Application number: 2025/62/93140/E	
What is the application for?:	Installation of replacement shop front and roller shutter (within a Conservation
Address of the site or building:	Kami Healthcare Ltd, 8, Market Place, Birstall, Batley, WF17 9EL
Postcode:	WF17 9EL

Type of comment: An objection	
Do you wish your comments to be published on the website anonymously?	Yes
1) The premises: This is a Grade II listed building within the Birstall Conservation Area and faces directly onto the Market Place. The Market Place is an important historic focal point of Birstall and was originally designated as a conservation area in 1998, in recognition of its 'special architectural or historic interest, the character of which it is desirable to preserve and enhance, now and for future generations'. Regarding the commercial properties facing onto the Market Place (one of which is a property in this application), the Birstall Area Conservation Appraisal (https://www.kirklees.gov.uk/beta/trees-listing-and-conservation/pdf/conservation-appraisals/Birstall.pdf) states: <ul style="list-style-type: none">• several of these commercial properties suffer from poor shop frontage. At strategic points insensi

Proposed Front Elevation

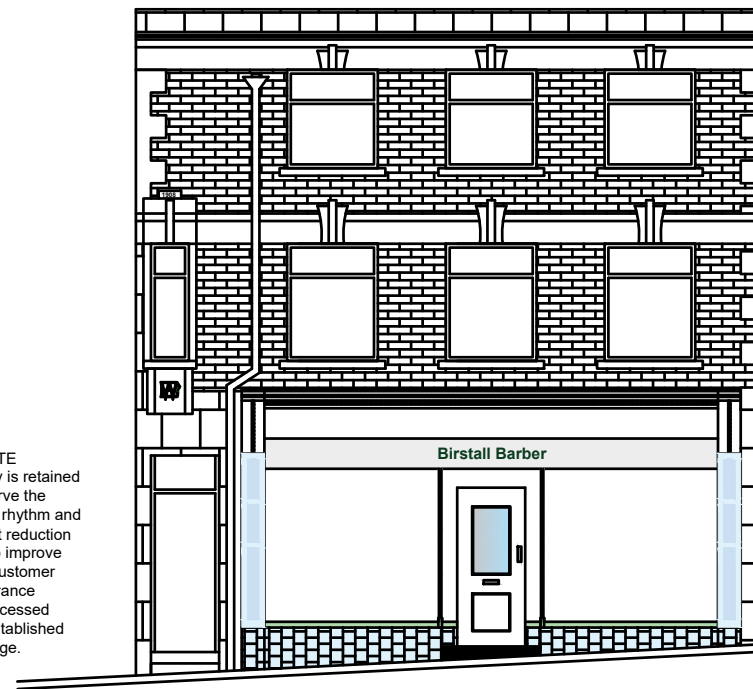
The current proposal does not fully reinstate or faithfully reproduce what was lost, notably the stained-glass windows, which were a key feature of the original frontage. As such, it cannot reasonably be said to “preserve” the historic shopfront as the application suggests.
